HOMESTEAD NORTH AT STERLING RANCH

EARLY GRADING AND EROSION CONTROL PLANS

Engineering Review

PCD Filing No.:
SP-20-008

SHEET 3 OF 10
JOB NO. 25188.00

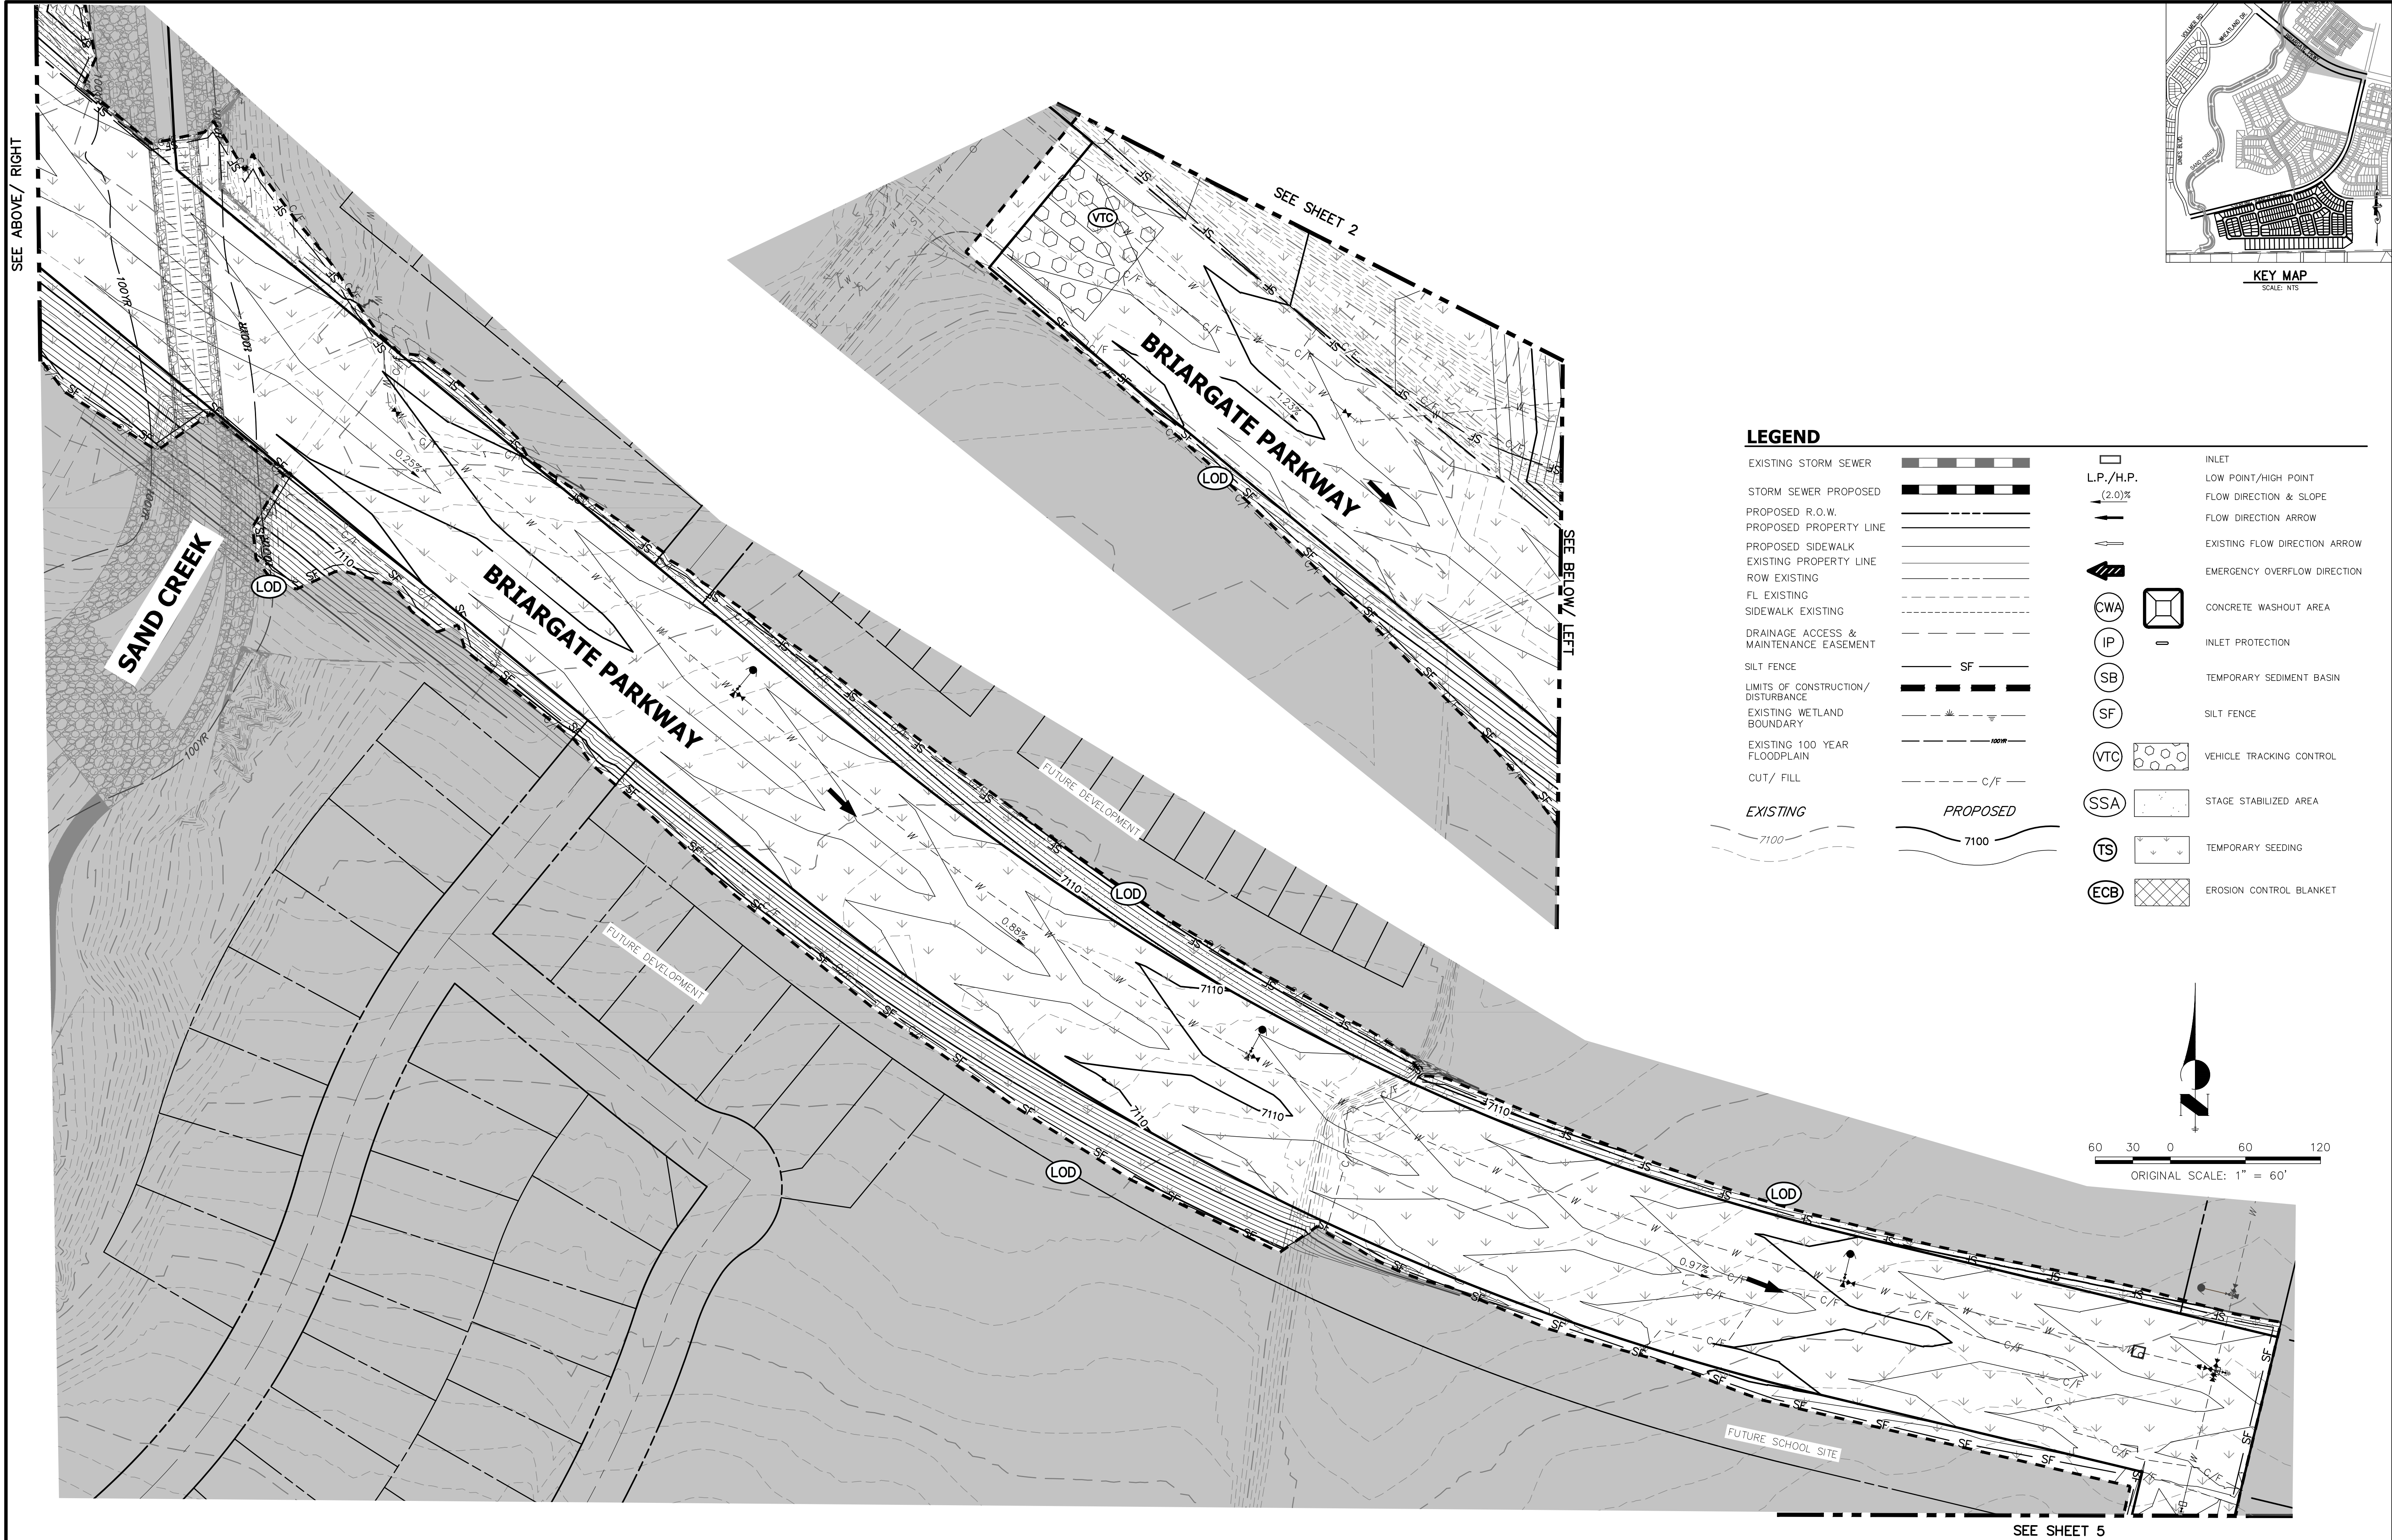
For SP review with EGP, remove C&G and sidewalks and just show rough cut of site and roads (line showing edge of roads is ok). Also remove all storm lines and inlets from the Pre-development GEC plan. Provide means of conveying the runoff to the temporary sediment basin such as a temporary swale.

and place check dams as needed throughout swales. If used, add check dam detail to sheet 5.

Show access road/trail grading through disturbed areas. Will retaining walls be required?

show flow direction arrows in areas southeast of Wheatland Dr.

show riprap pad per detail. Label with dimensions on riprap area.

Show slope of steep grading (typ)

Show location of spillway per MHFD detail

label riser outlet with design details like size and orifice holes per MHFD detail

Checklist item "e" - show property boundary that runs through this area, as shown on Prelim Plan, sht 6.

label adjacent subdivision/filing

Revise to 75ft length

label adjacent subdivision/filing

Checklist item "cc" - show existing and proposed easements.

Seeding and Mulching shown in FAE, but not on GEC Plans or Legend below. Add to plans/legend if applicable or add a note explaining when/where to seed and mulch.
Also show location and label stockpile location or make a note that says location is TBD by contractor.
